WEST SUSSEX COUNTY COUNCIL CONSULTATION

TO: Arun District Council
FAO: Jessica Riches
FROM: WSCC - Highway Authority
DATE: 23rd August 2022
LOCATION: Ryefields Farmhouse
Oak Tree Lane
Chichester
PO20 3GU

SUBJECT: AL/31/22/PL

Demolition of existing building and erection of 4 no. houses with associated access, landscaping, parking and associated works. This site falls within Strategic Site SD5, CIL Zone 1 (zero rated).

Figure 1.3: Proposed Site Layout

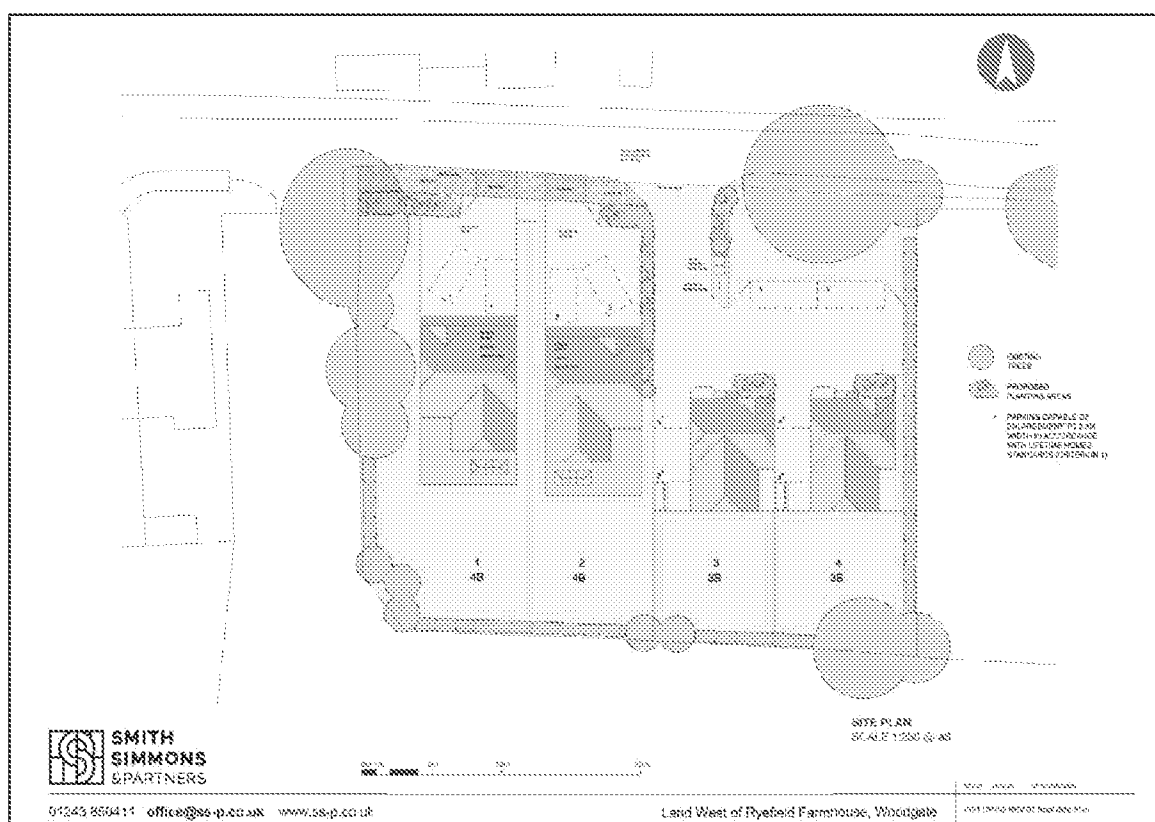
The western access serving Plot 1 is shown constructed as a domestic crossover leading to a parking area for four vehicles. The second access is shown with bellmouth radii of approximately 4.0m and leads to a shared driveway serving Plot's 2-4 and two visitor parking spaces. Parking is shown in front of all the plots with the aforementioned visitor parking shown in front of Plot's 3 and 4. Parking for cycles is shown as being within bespoke storage sheds (or similar). One visitor cycle parking stand is shown and is in accordance with that recommended in LTN 1/20. This should be provided as a Sheffield Stand or something very similar. A condition to secure all cycle parking should be attached to any planning permission.

The submitted drawings show a 2.0m-wide footway being extended from Oak Tree Close, terminating at the point the eastern-most access is located. Ramps for prams, pushchairs, mobility scooters etc. should be provided for users at either-end of the new footway. Tactile paving may also need to be considered if any crossing provides a continuation of any footway route.

On the north-east corner of Plot 2, landscaping is shown. Given that pedestrians would be moving between the shared drive serving Plots 2-4 and the new footway, it is recommended that the vegetation around the corner of Plot 2 is kept to 0.6m maximum height when mature to enable intervisibility between vehicle drivers and non-vehicle users.

1. Access (Access to be provided prior to first occupation)
No part of the development shall be first occupied until such time as the vehicular accesses and new footway serving the development have been constructed in accordance with the details shown on the approved drawing.

FIGURE 1.6

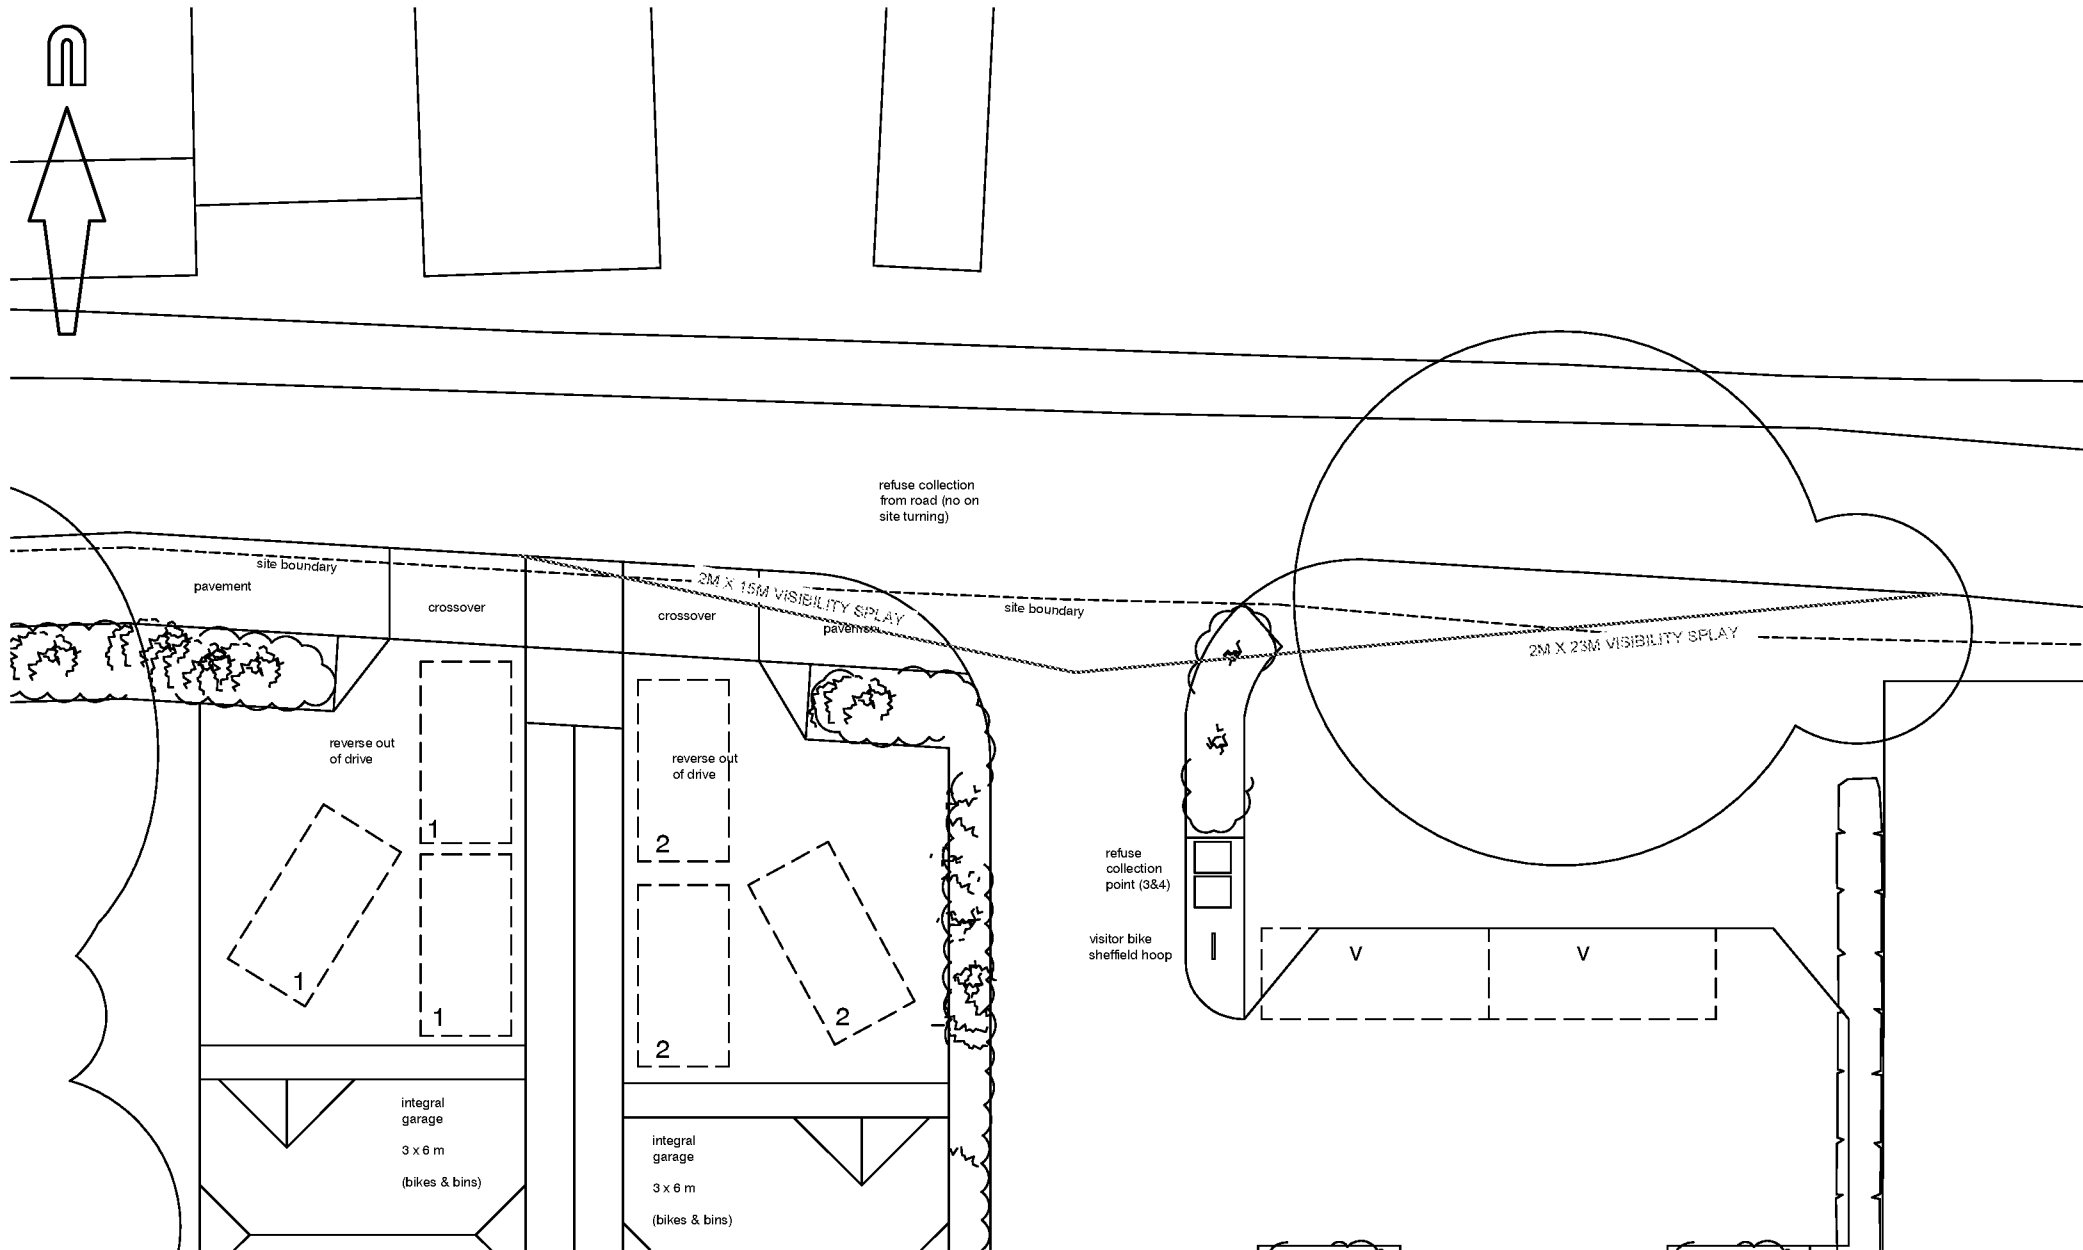
Further to this, visibility splays are shown at the access point where it joins Oak Tree Lane of 2m x 23m in the leading traffic direction (looking east) and 2m x 15m in the trailing traffic direction (looking west). In practice, visibility would extend further given the creation of the new footway when looking west. On-site provision for both refuse and fire appliances is not provided on this occasion. WSCC Fire and Rescue Service has said that the site is very close to meeting access and water requirements. The nearest fire hydrant is 75m away; furthest point from Oak Tree Lane is approximately 35m and a fire appliance would need to reverse 25m to turn and make their exit, which is 5m further than the 20m distance to a turning head which is slightly over distance depending how far in the appliance drives. With regard to operational requirements when stationary, a fire appliance requires 3.7m to operate all their equipment, plus 3.7m is an access requirement to comply with Approved Document – B (AD-B) Volume 1 B5 section 13. The width of Oak Tree Lane to the north of the site measures between 4.0-4.2m wide which exceeds the operational width. Finally, the proposed access serving Plots 2-4 measures 5.0m wide.

2. Visibility splays
No part of the development shall be first occupied until visibility splays of 2.0m by 23m to the east and 2.0m by 15m to the west have been provided at the proposed site vehicular access onto Oak Tree Lane in accordance with the approved planning drawings. Once provided the splays shall thereafter be maintained and kept free of all obstructions over a height of 0.6 metre above adjoining carriageway level or as otherwise agreed.
